Our ref: DOC22-413307
Sender's ref: SSD-5285-MOD1

8 June 2022

Subject: Balranald Mineral Sands Mine MOD 1 - Extension of underground mining trial (SSD 5285 MOD 1)

ATTACHMENT A – BCD comments on Balranald Mineral Sands Mine MOD 1 - Extension of underground mining trial (SSD 5285 MOD 1)

PCTs in the study area
Map 1 of 4

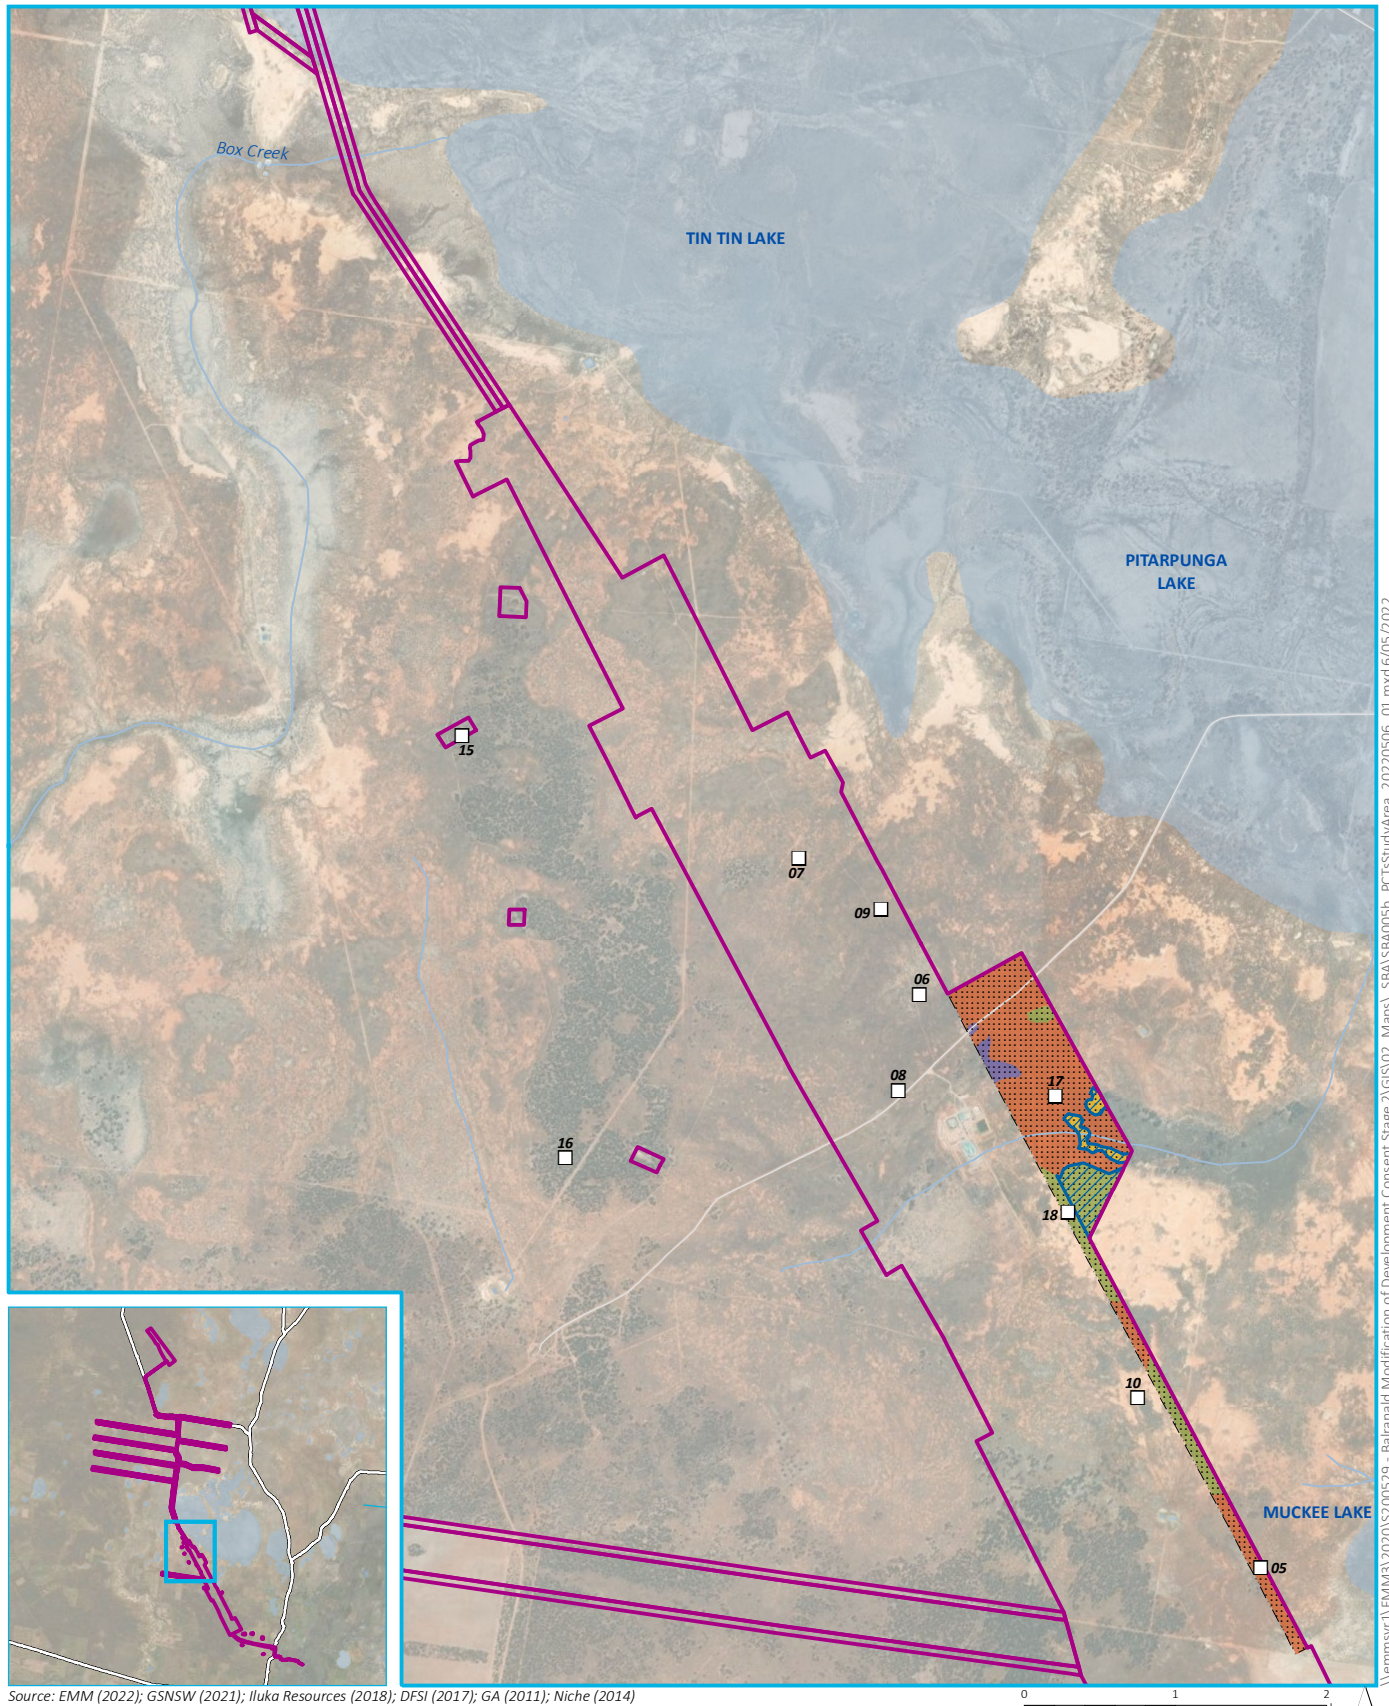
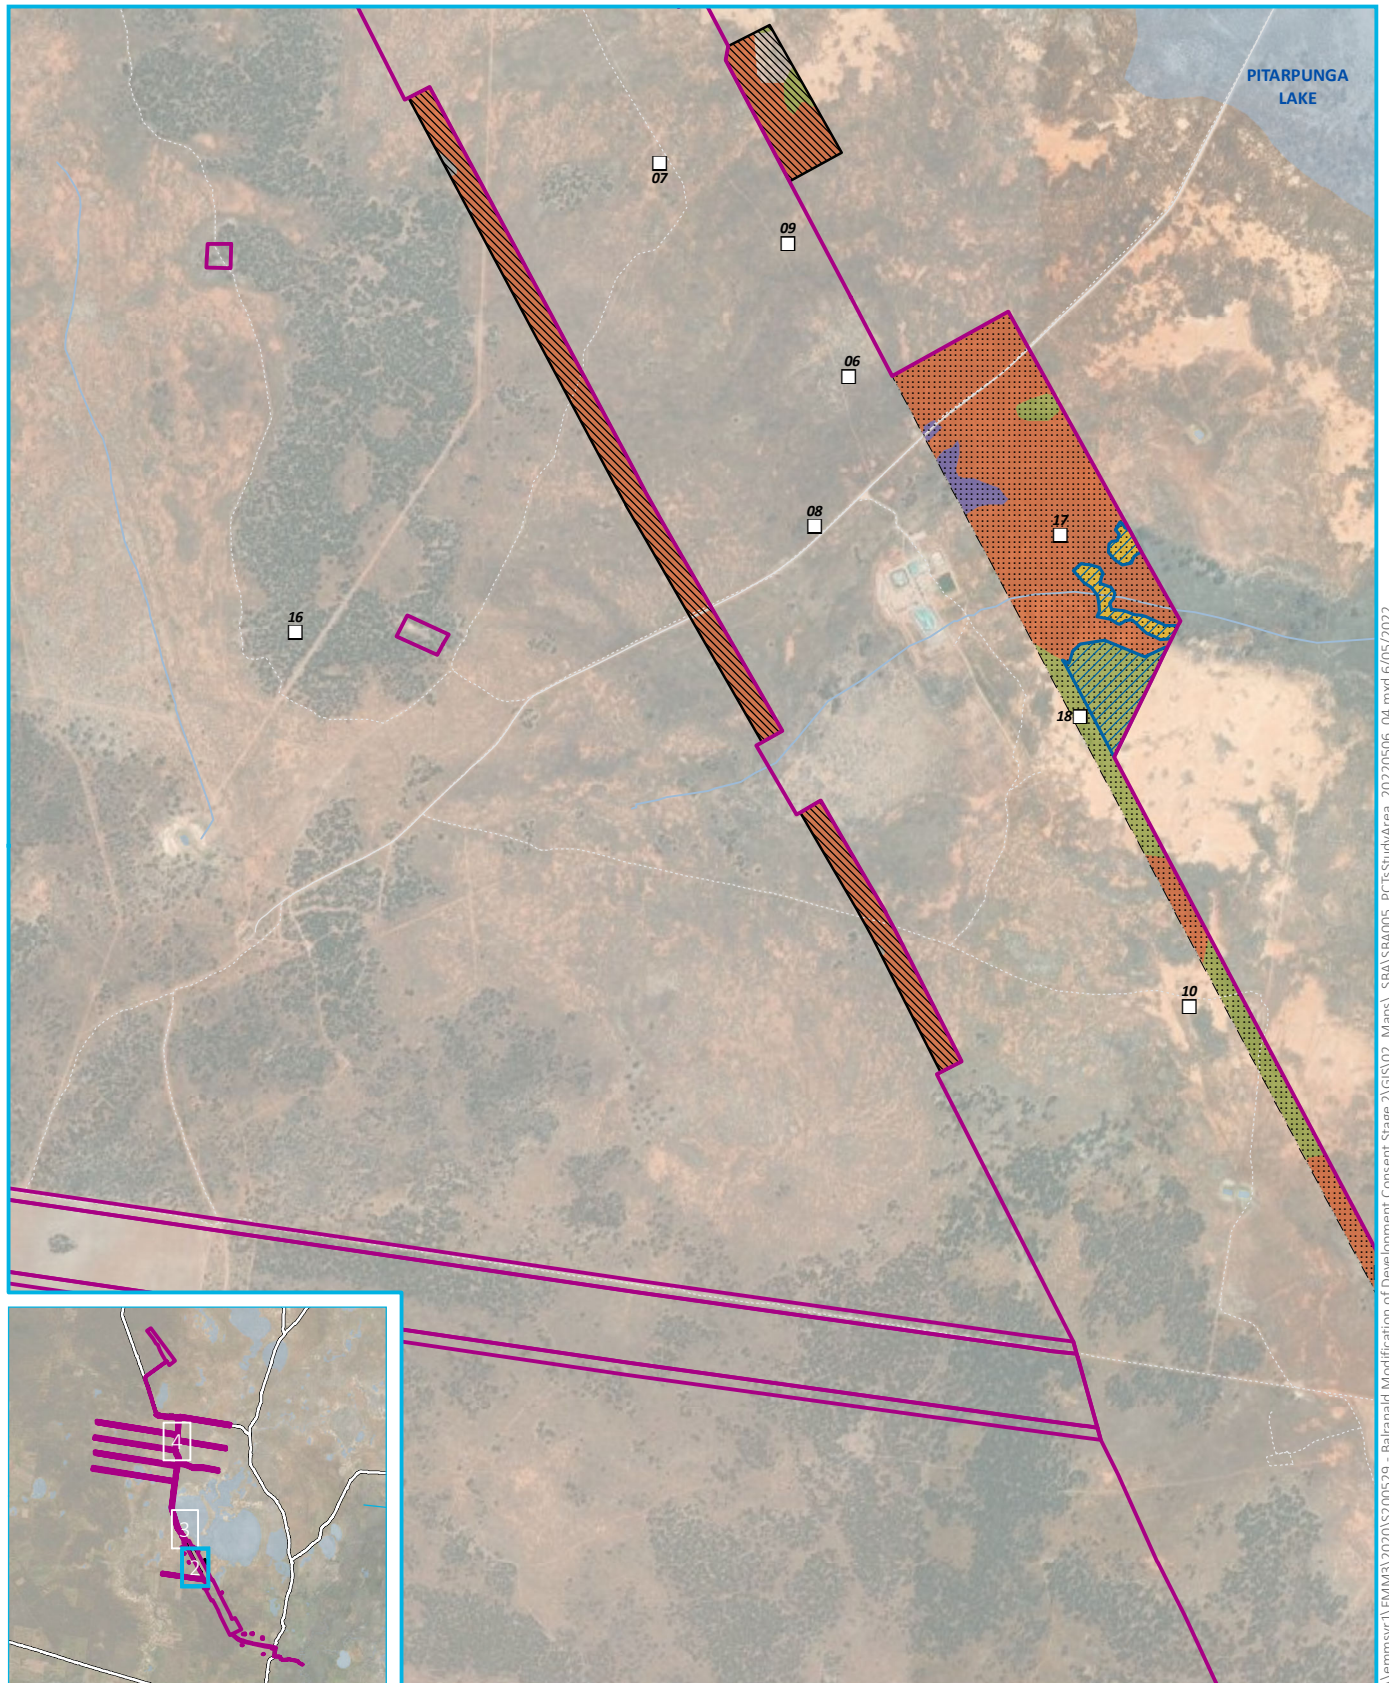
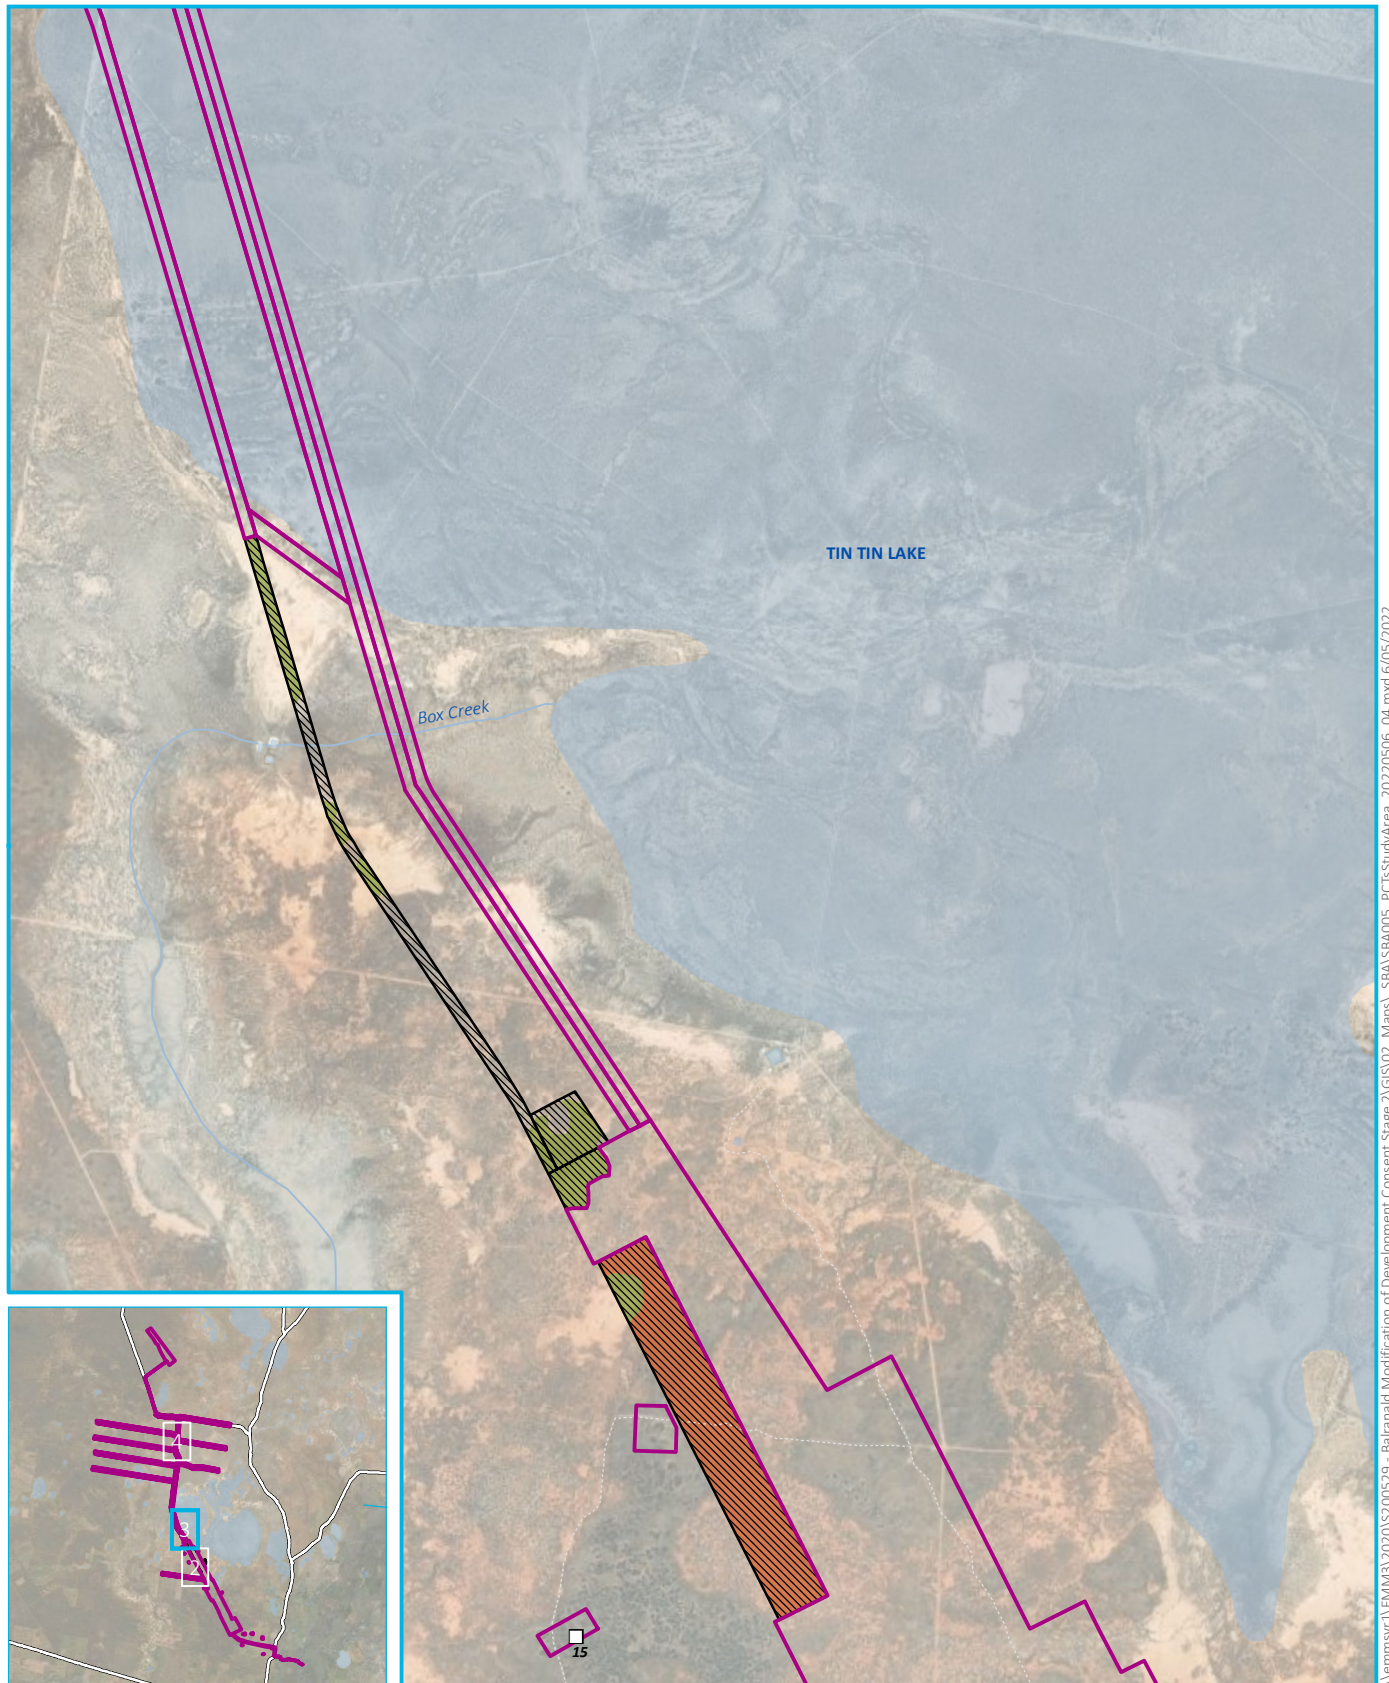
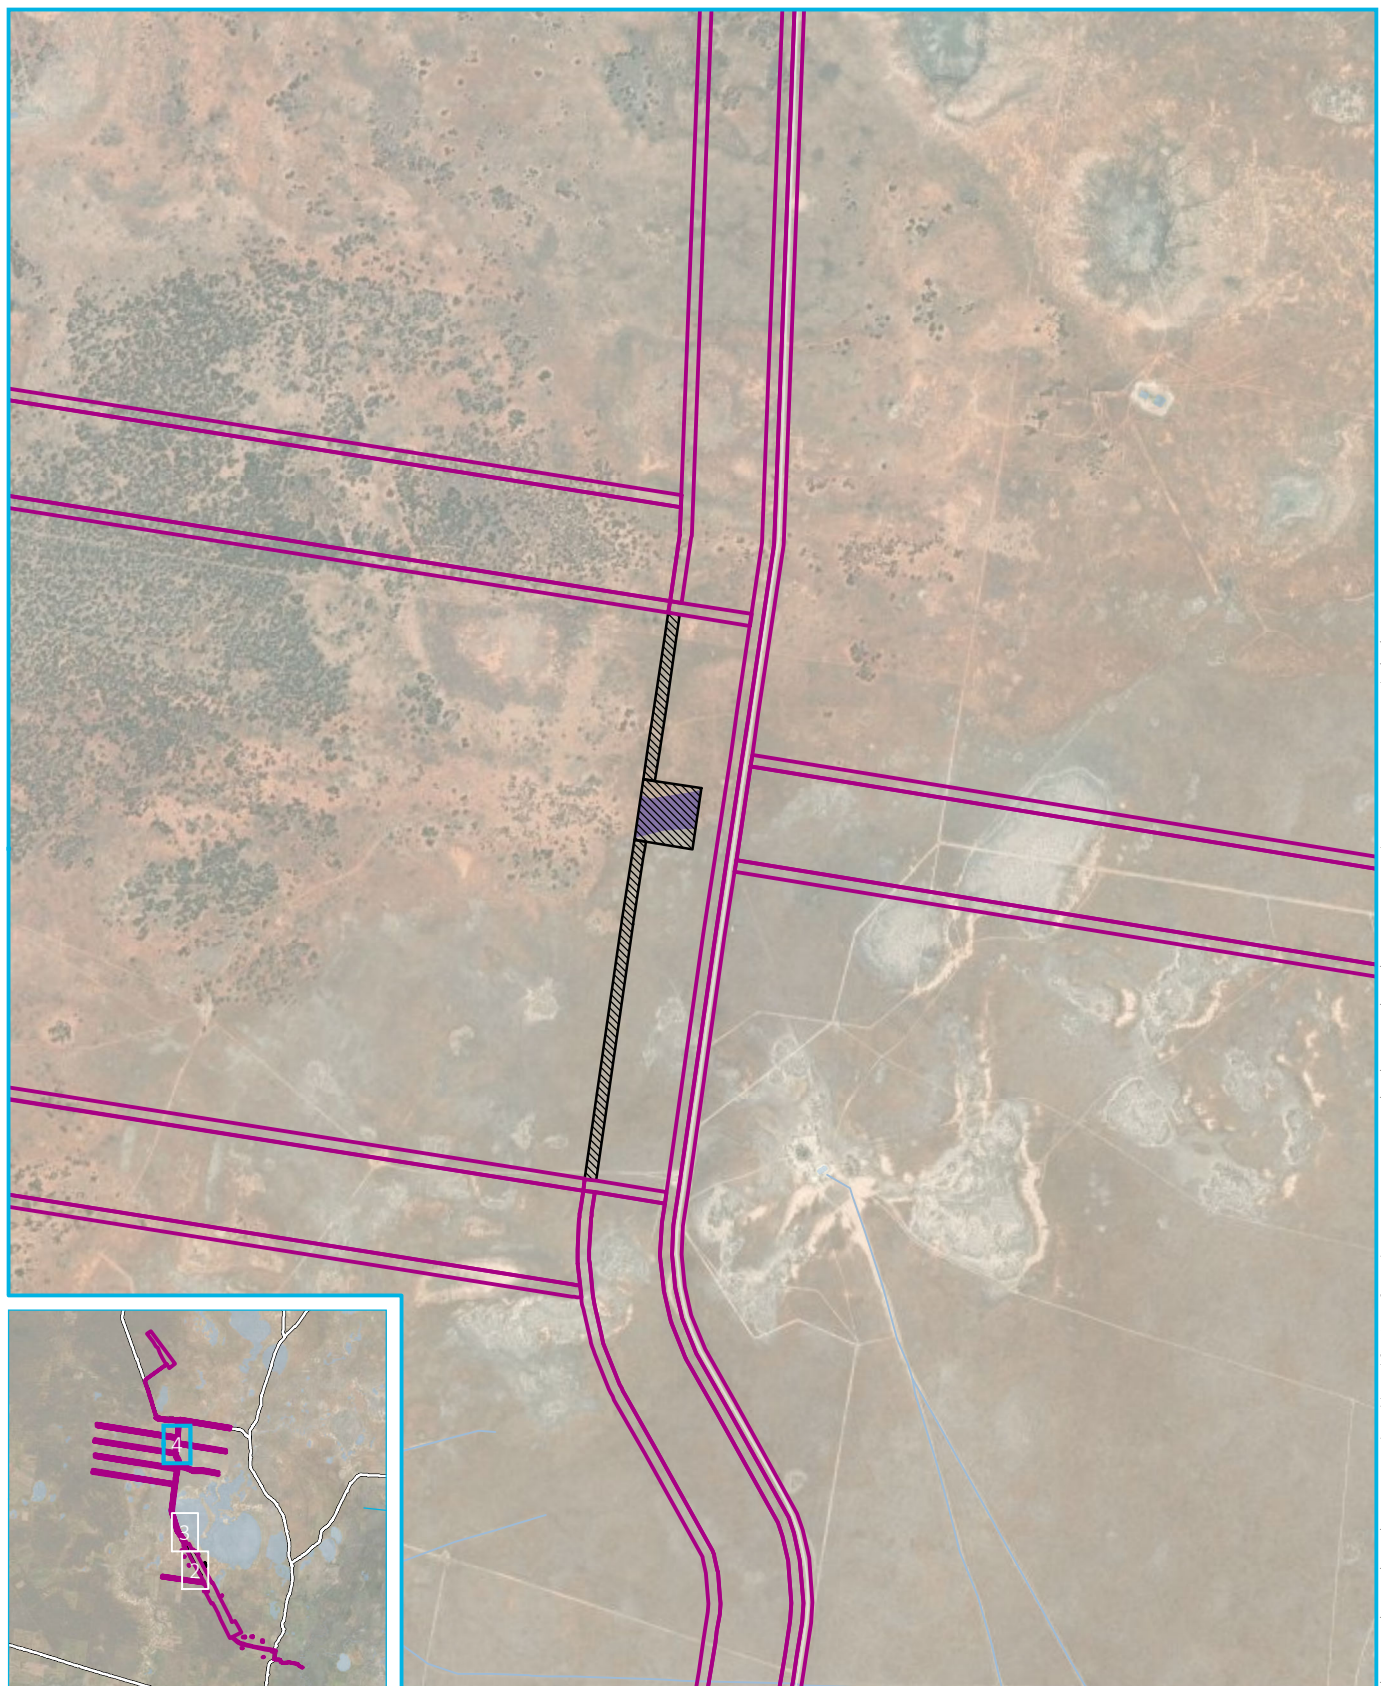
The context of the excise areas needs to be considered in relation to surrounding vegetation. According to the assessment, within the Mod 1 area is a patch of PCT159 - Old Man Saltbush shrubland mainly of the semi-arid (warm) climate zone (south western NSW), surrounded by PCT154 - Pearl Bluebush low open shrubland of the arid and semi-arid plains. This combination, but especially the old man saltbush shrubland, provides preferred habitat for the threatened bird species, Redthroat (*Pyrrholaemus brunneus*).

Ideally, the replacement excised areas, in particular the assumed PCT159 area, will also provide suitable habitat for the Redthroat. It would be preferable to demonstrate that the excised area is surrounded by suitable habitat and is not an isolated remnant patch.

While it is understood that further BAM surveys have been conducted in May 2022 these results are not presented in this report. It is therefore not possible for BCD to assess the appropriateness of the areas being used to offset the Mod 1 clearing.
